Re: 2020/0289 Albion Works, Hunningley Lane, Stairfoot

Further to your email dated 21 July 2020, please find below the replies to your queries.

SITE PLAN

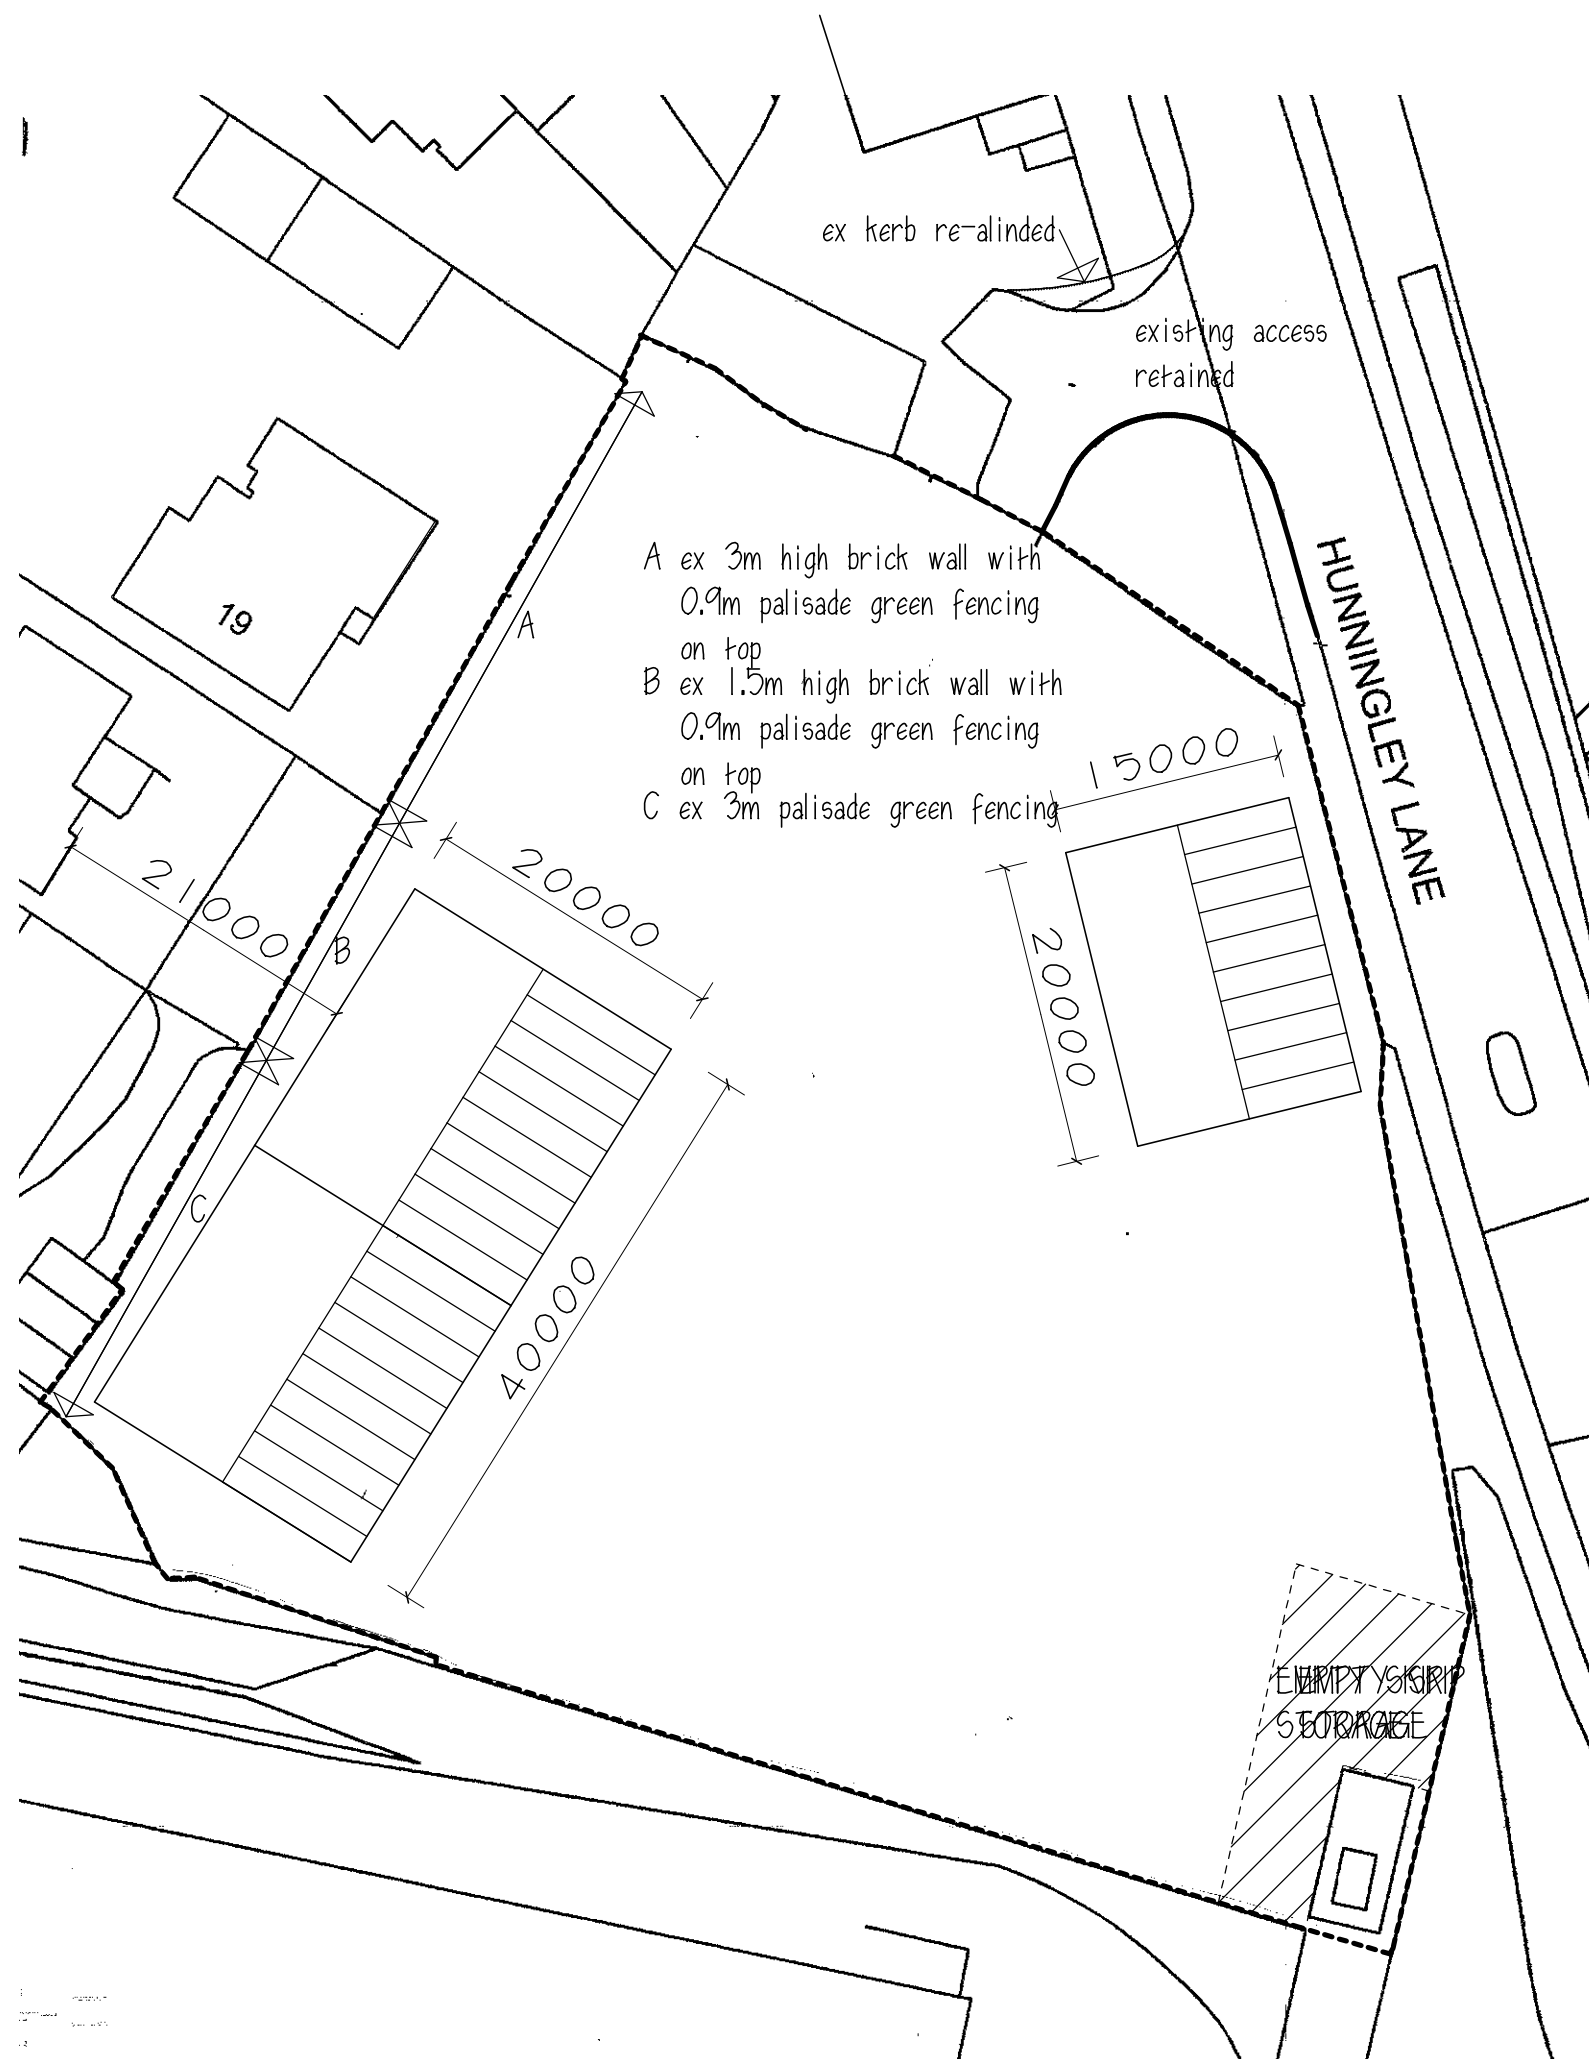
3. Where are the skips to be stored, will they just be empty skips? **The skips and trailers will be stored on the B & Q boundary and the Hunningley Lane boundary lines.**

6. Is the existing vegetation immediately in front of the residential properties to remain or be removed? **We are planning on leaving the vegetation in and adding to it in areas.**
